From: Gary Alford [REDACTED]
Sent: 08 September 2014 13:23
To: Charlotte Burrows
Subject: RE: Further Information Required on Your Ref: PP-03618733 Our Ref: R/196/14/HH
Attachments: 002 Anstee Planning Rev C pdf.pdf

Drawn By:	G . A
Drawing Status	
For Planning	
Project :	Loft Conversion Rear Extension
Mr M Alstee 3 The Bramblings Rustington BN16 2DA	
Drawing	
Elevations and floor plans Location and Block Plans	
Scale :	1:100/1:500/1:1250 @A1
Job No:	A-054
Drawing No :	A-054-01
Revision :	C

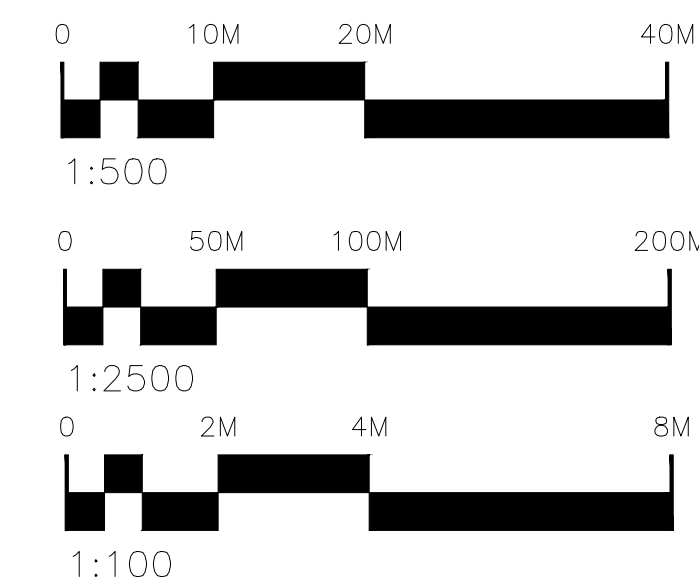
Please could you amend the floor plans at first floor level to indicate all windows in the same way you have all the others.

Hello Charlotte
Please find the updated drawings you asked for
The cheque should be down stairs at the planning reception today
Any other info you need please let me know
